Application by SEGRO Properties Limited for an order granting consent for the East Midlands Gateway Phase 2 (BC0410001) and East Midlands Rail Freight Interchange Material Change (TR0510002)

Deadline 4 submission

East Midlands Gateway Phase 2 – East Midlands Gateway Rail Freight Interchange Material Change - LCC responses to Examining Panel (ExP) second questions – Deadline 4 – 16th June 2026

Drawing Title
**PARAMETERS PLAN
(EMG2 Works)**

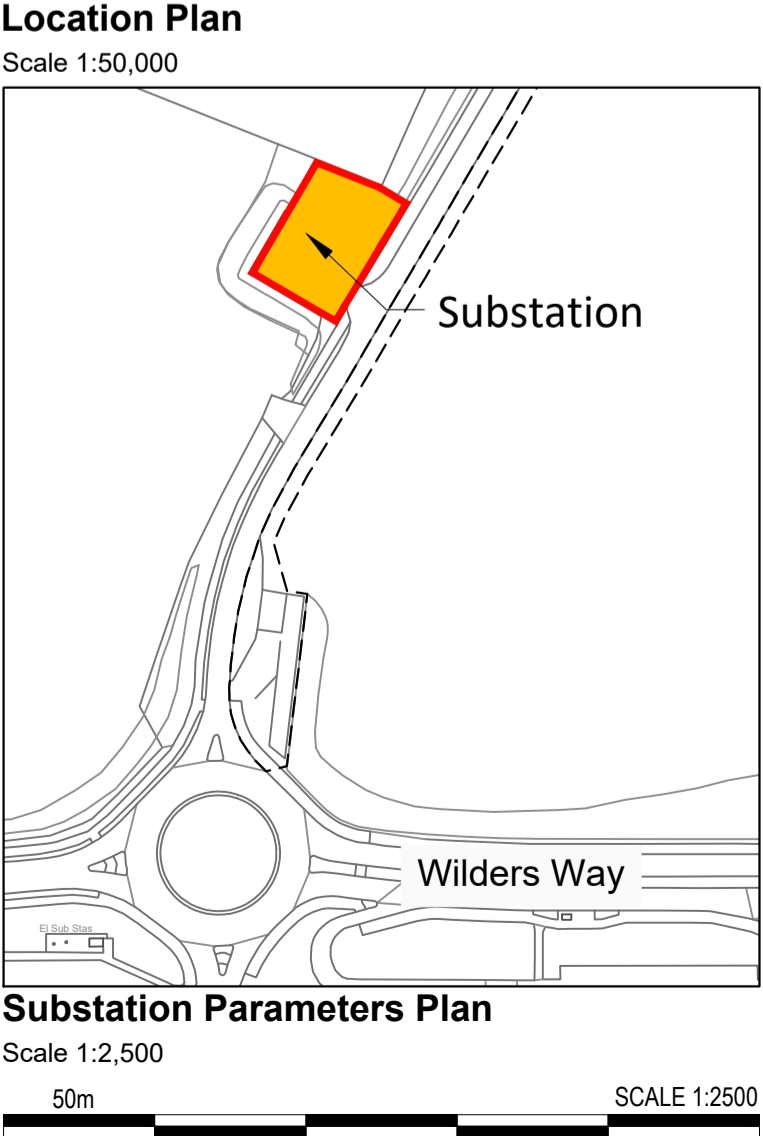
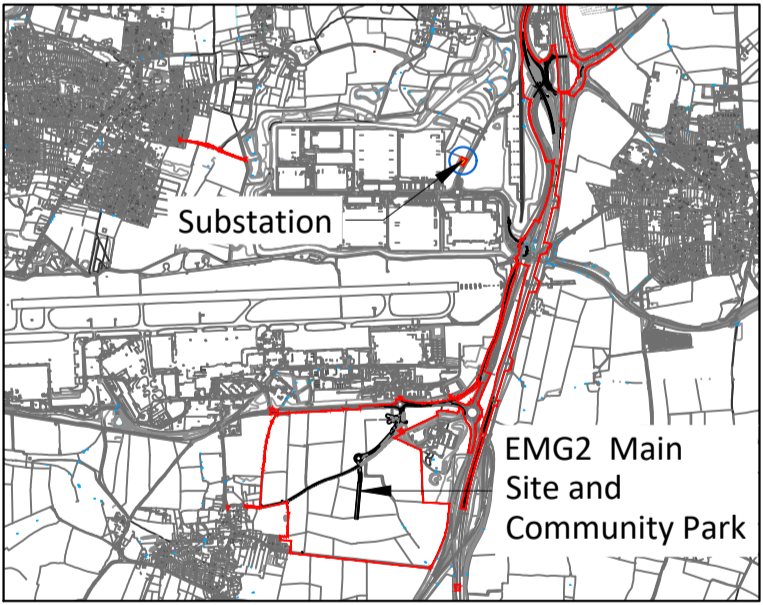
Examination library reference	Document name	Leicestershire County Council (LCC) comments on dDCO/MCO
REP2-009D	DCO 3.1 Draft Development Consent Order (dDCO) (April 2026)	<p>Requirements LCC consider to be missing from the DCO:</p> <ul style="list-style-type: none"> • Public Rights of Way – LCC raised concerns with the Applicant about the absence of a requirement for the implementation of works to Public Rights of Way. The Applicant is reliant on Schedule 5 of the DCO. LCC in its capacity as Local Highway Authority consider the commitment should be explicit in the Order and not implicit. This remains a matter of disagreement between LCC and the Applicant • Construction Traffic Management Plan (CTMP) - LCC raised concerns with the Applicant about the absence of a requirement to implement the CTMP. The Applicant had previously advised that they were considering amendments to Requirement 11 to address this matter. However, this is yet to be addressed. • HGV Route Management - LCC raised concerns with the Applicant about the absence of a requirement to control HGV routeing to and from the site. The Applicant had previously advised that they were considering inclusion of such a requirement. However, this is yet to be addressed. • Safeguarded land – LCC welcomes the inclusion of Requirement no. 31 to safeguard land along the EMG2 main site frontage with the A453 for future dualling. However, as raised by LCC at Deadline 2 [REP2-046] the submitted plan [REP1-024D] does not go far enough in securing land across the entire site frontage.
